Congress St - Outstanding Site Plan Related Conditions

Thu, Jul 25, 2019 at 1:45 PM

TITLE  
**SITE PLAN,  
GILMAN STREET,  
CONGRESS STREET  
EXPANSION**

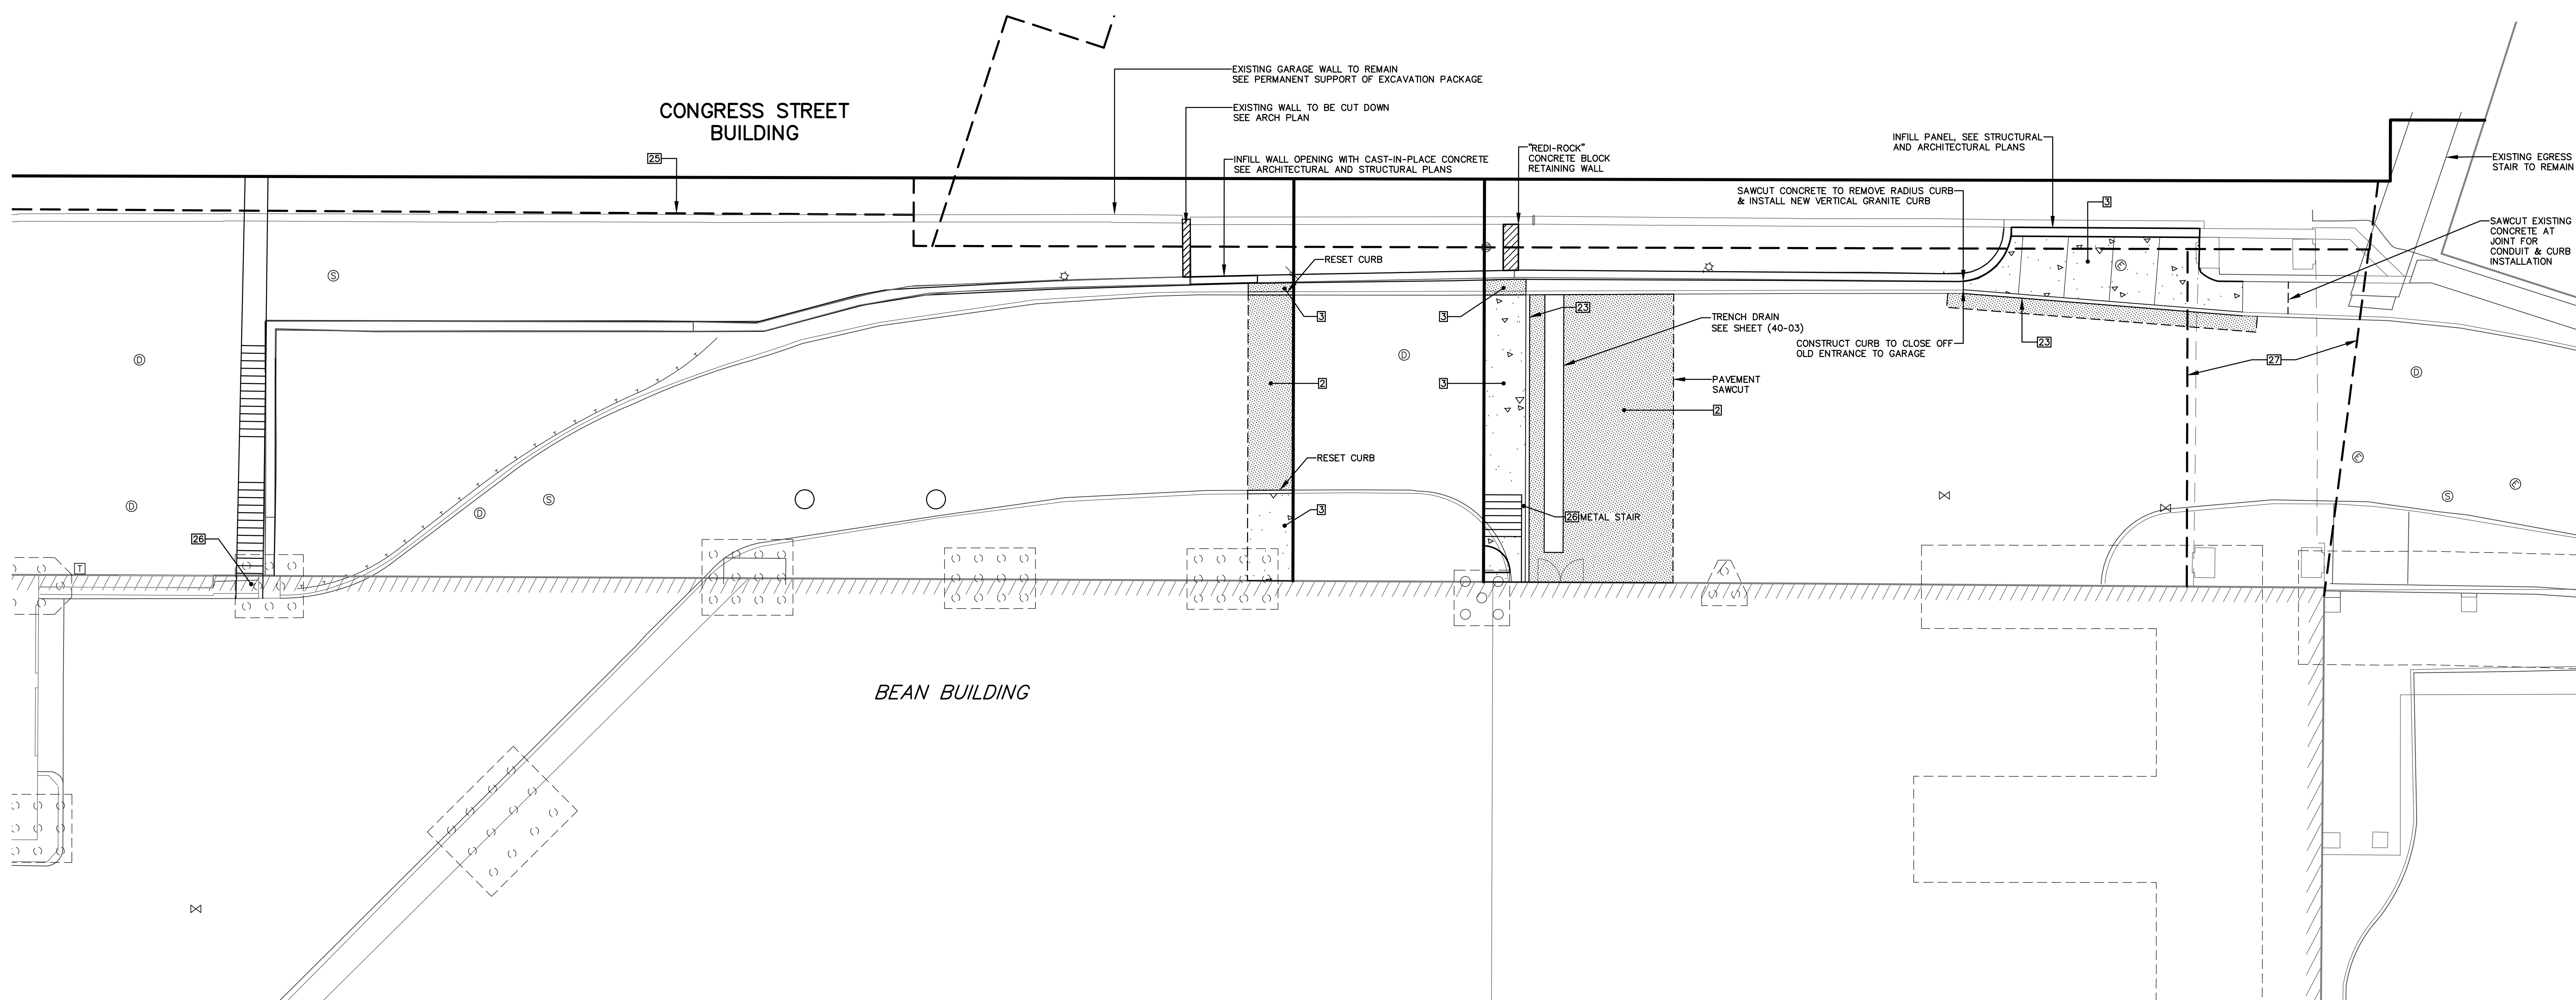
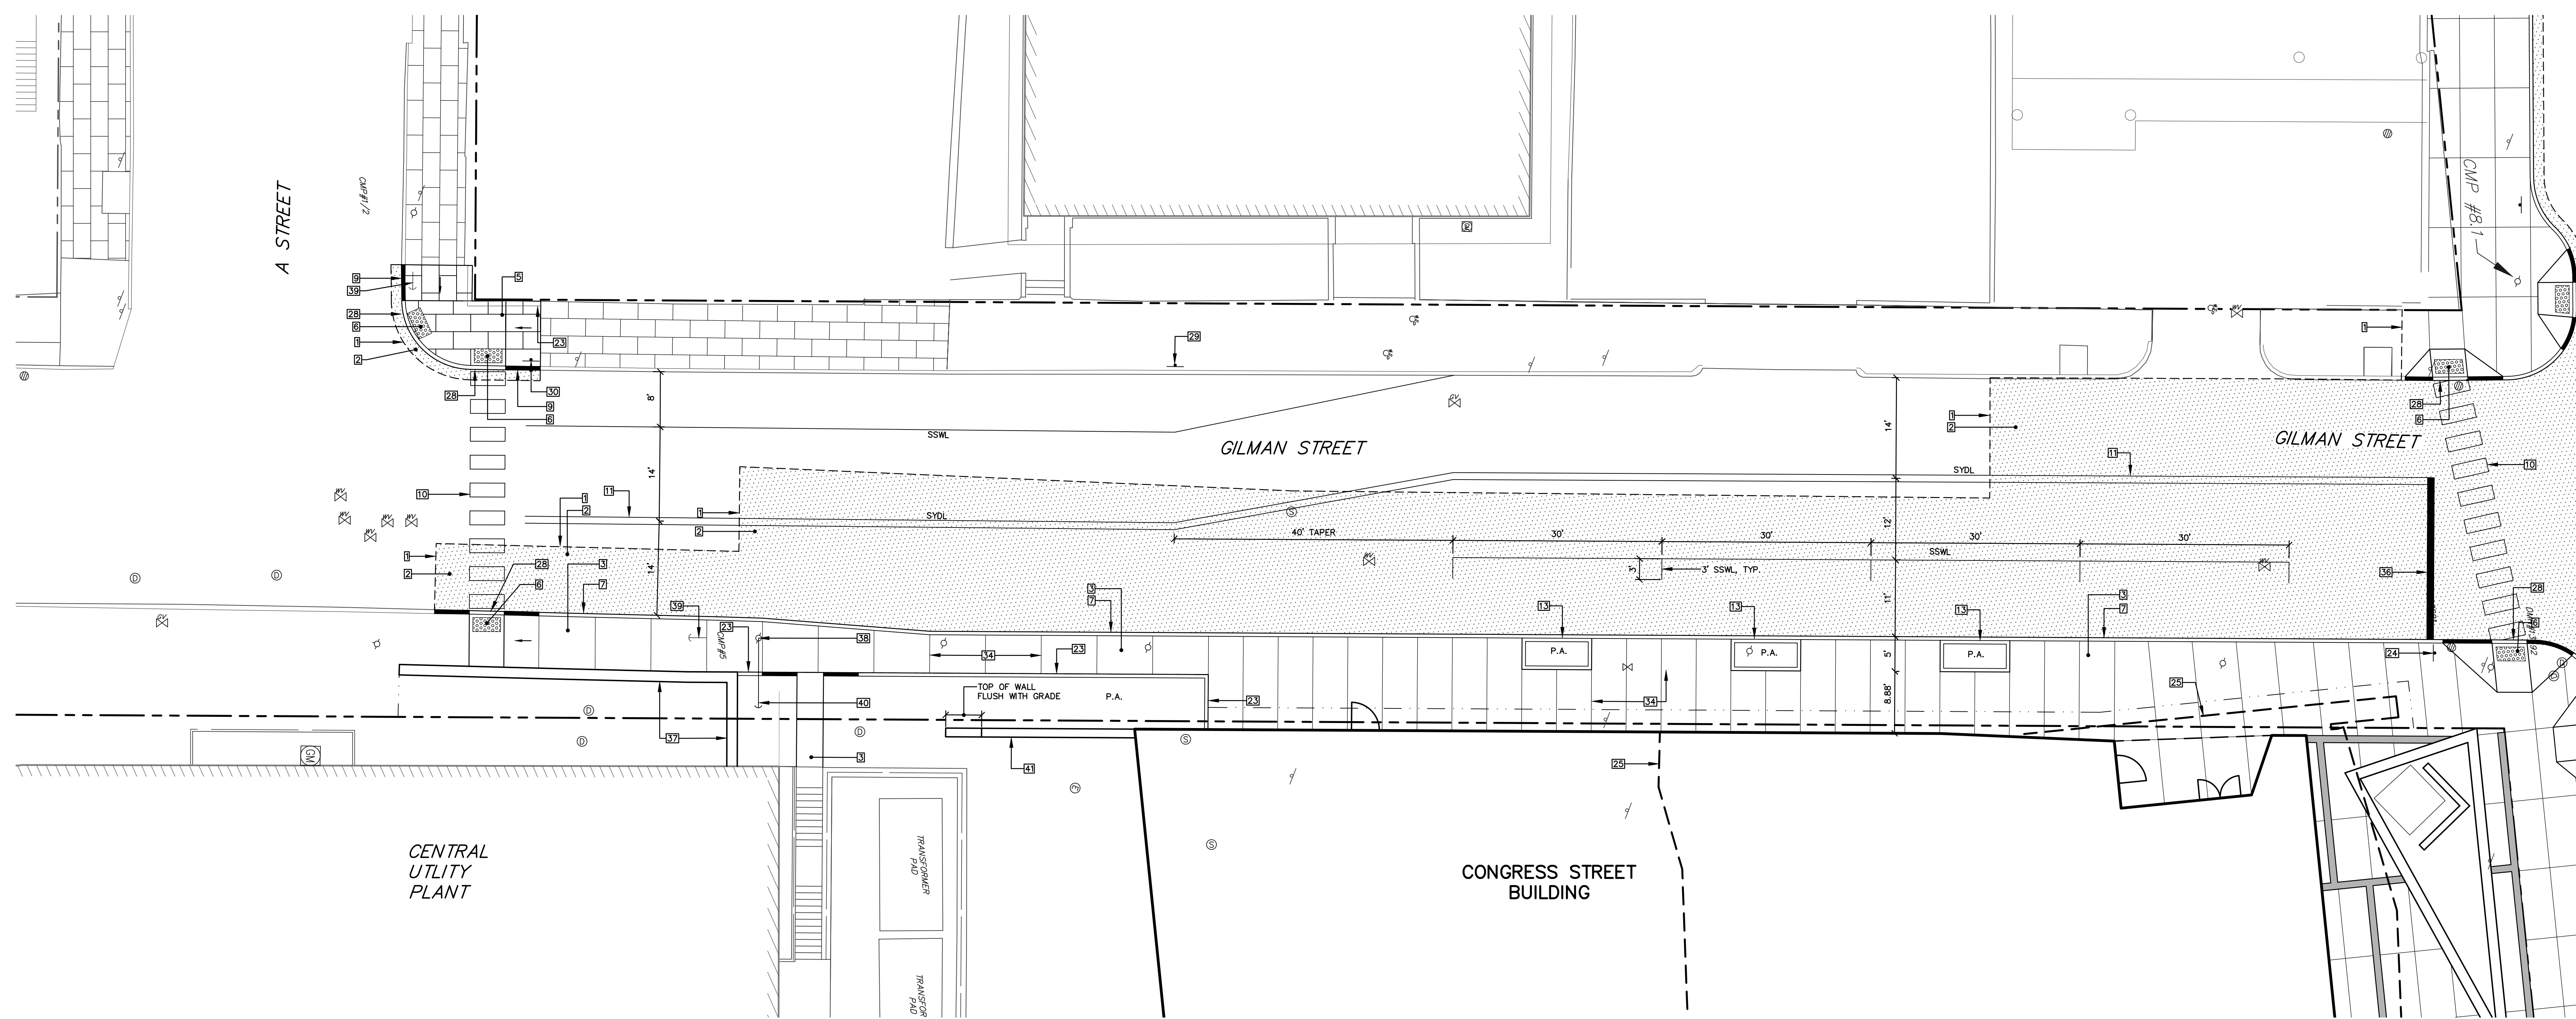
Hi Nell – I certainly agree with the comments provided and nothing to add at this time given the extent of changes to come. I would note that Gilman from Congress to Park is one-way and the pavement markings should reflect this.
